Subject: M/88/21/PL

155 Middleton Road Middleton-On-Sea PO22 6DF

Coffee trailer business to be located on the shingle area adjacent to the paved forecourt. This application may affect the setting of a listed building & is in CIL Zone 4 (Zero Rated) as other development

Proposed Trailer (nts)

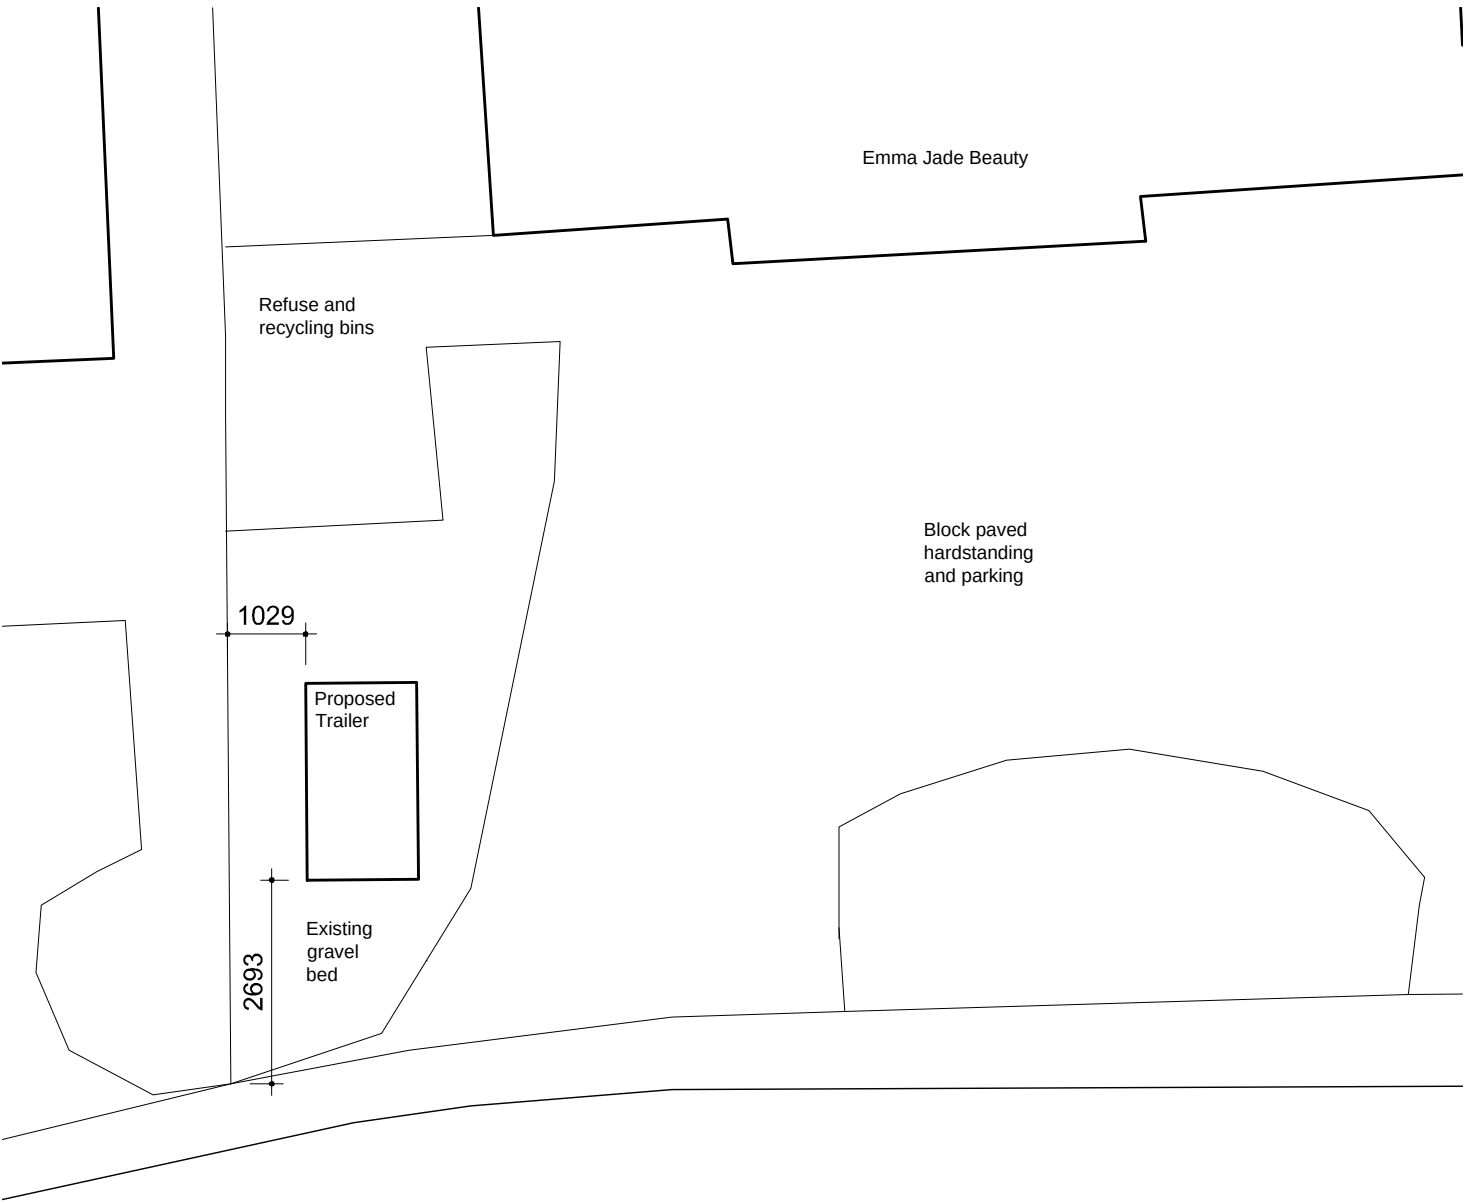
The proposal is for the introduction of a coffee trailer business on an area of shingle which is adjacent to the existing paved forecourt. It would appear to cover an area of 2.6m by 1.5m, and be located so as to be visible from the road to the front of the site. However, it would also be located in a vibrant village centre where there a mixture of shops and other uses, along with pedestrians and vehicles.

The trailer itself, would not be a permanent fixture and could be easily removed. It would appear that the trailer would be a black colour with white lettering (as indicated on the photograph mock-ups). I am of the opinion that the appearance would be acceptable, subject to confirmation.
